APPROVED
Limited building only review
Permit holder responsible for full compliance with the code

PROPOSED
RESIDENCE
FOR
ANDREW & ANITA
RUHLAND
155 MOCKINGBIRD LANE
SPRING LAKE, NC 28390

fFOUNDATION PLAN

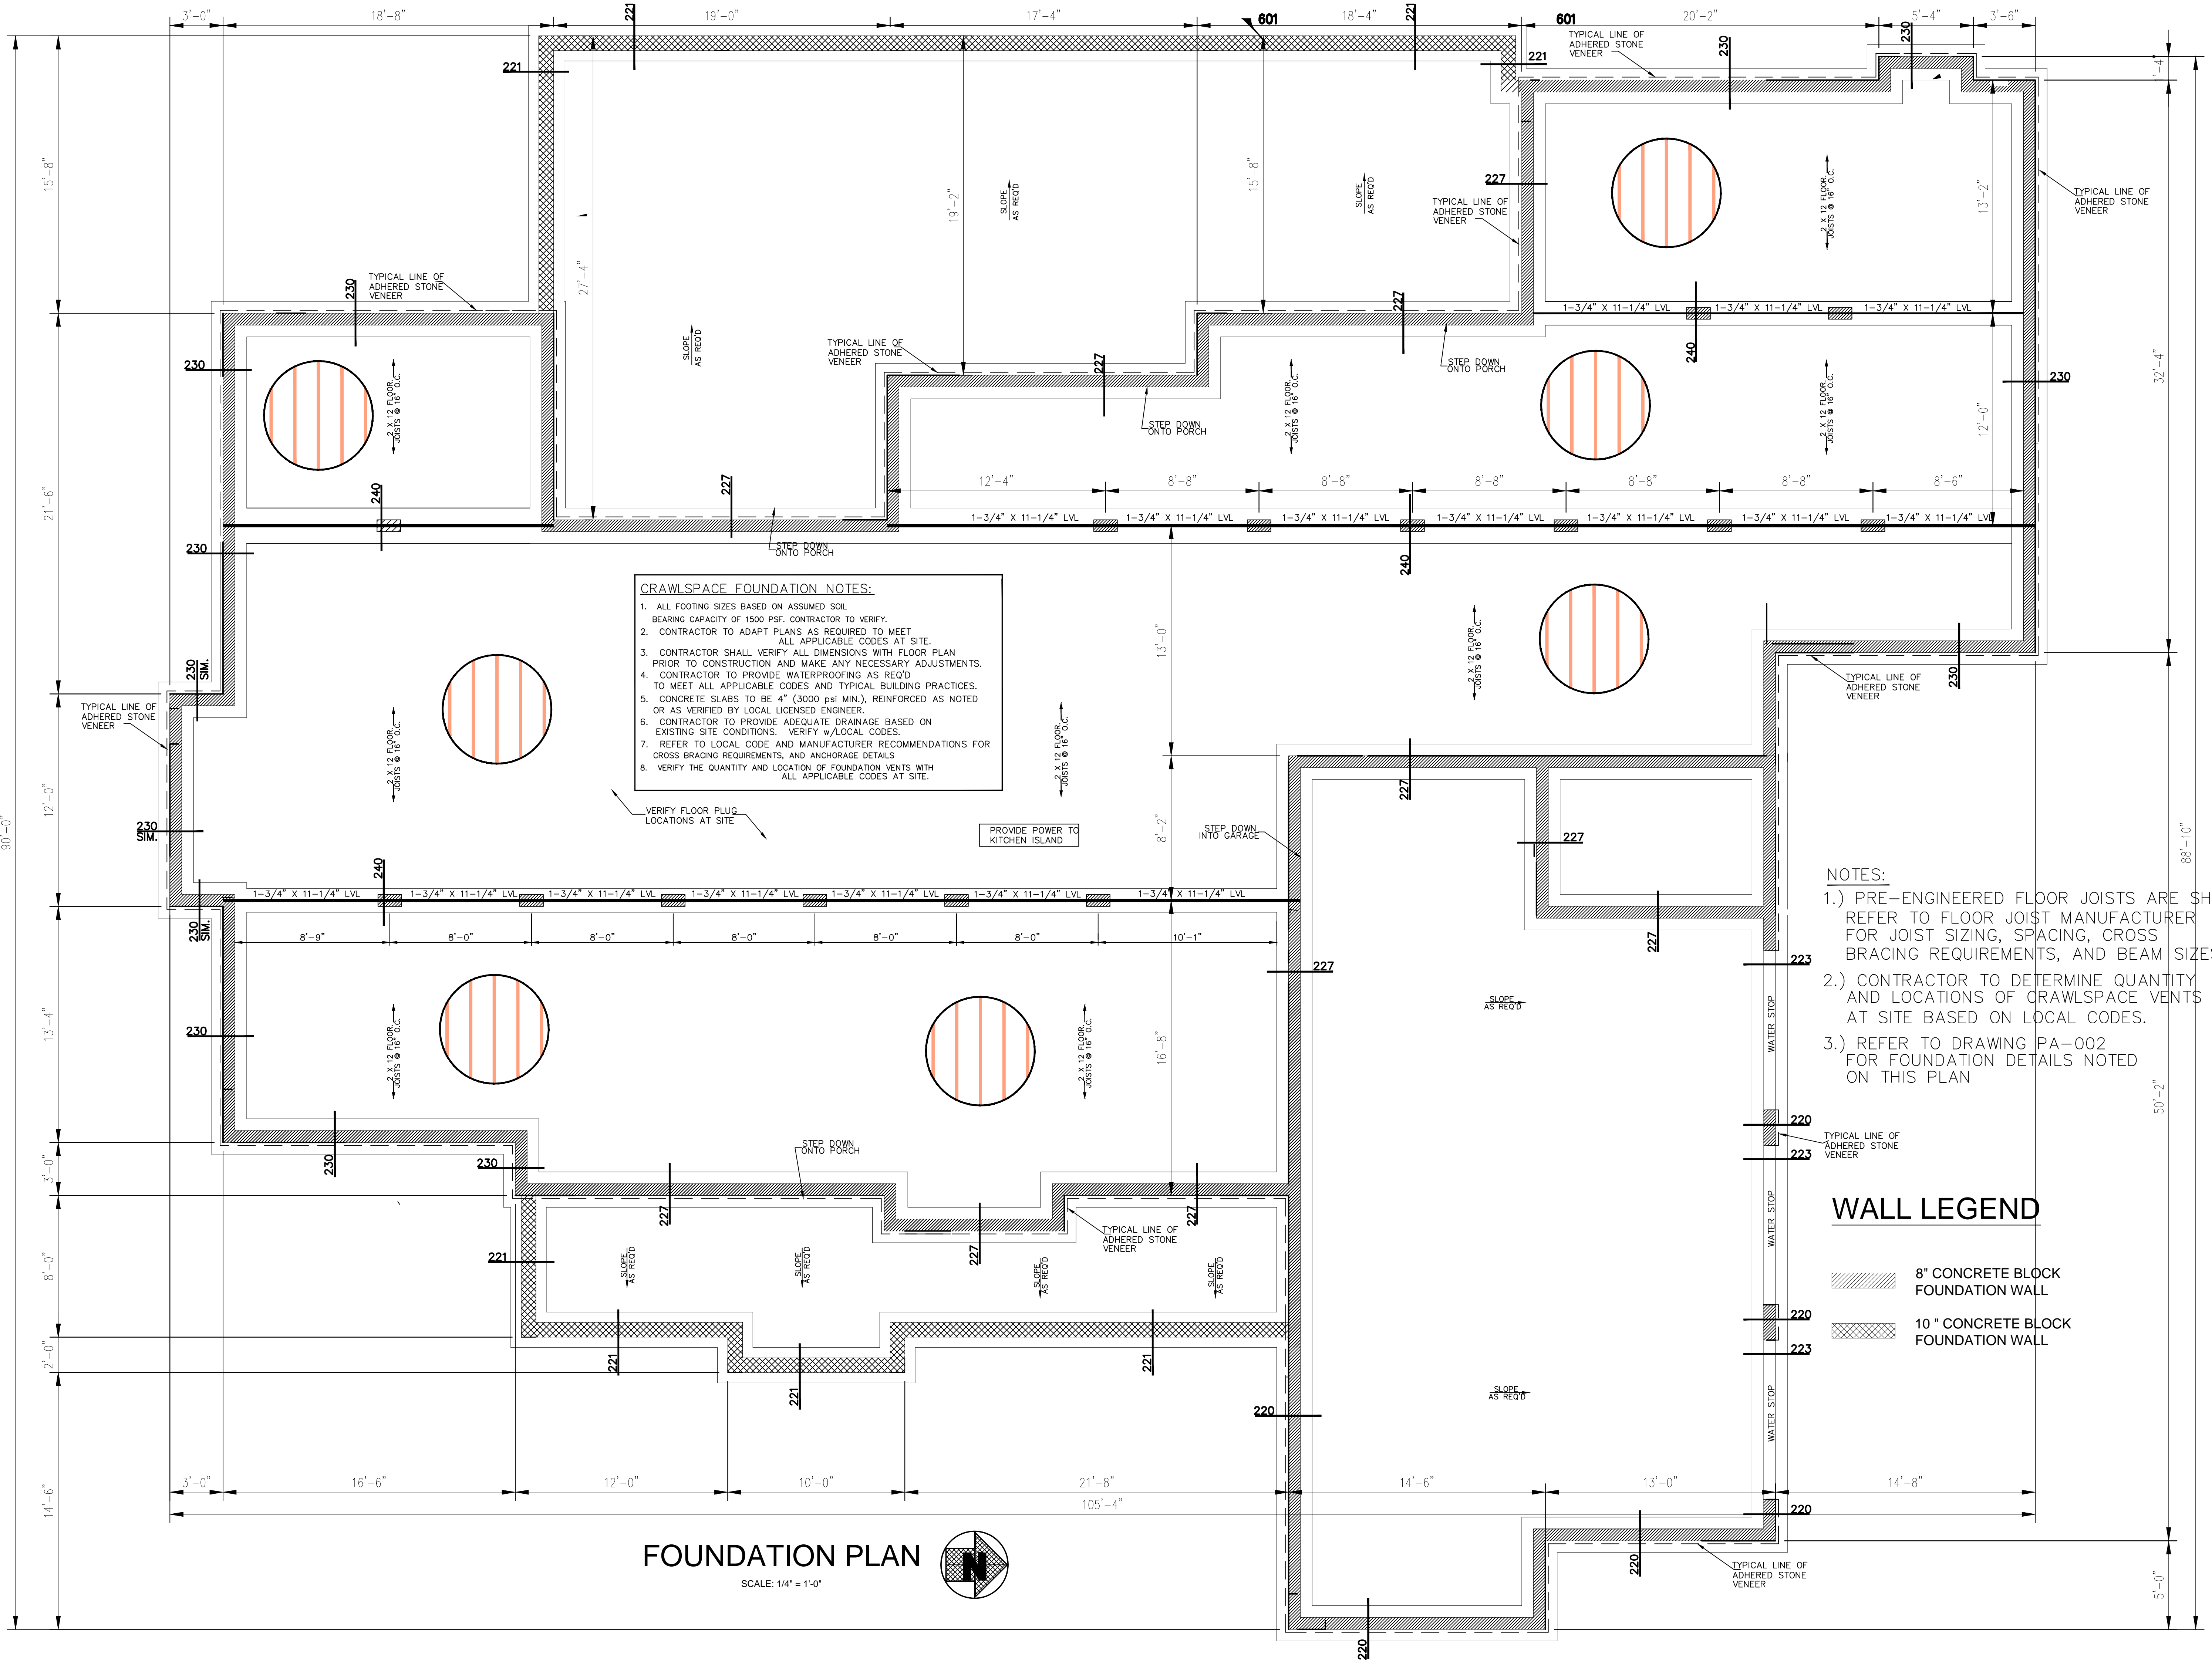
MUST USE I JOISTS. 2x12 WILL NOT SPAN THIS FAR

MUST USE I JOISTS. 2x12 WILL NOT SPAN THESE DISTANCES
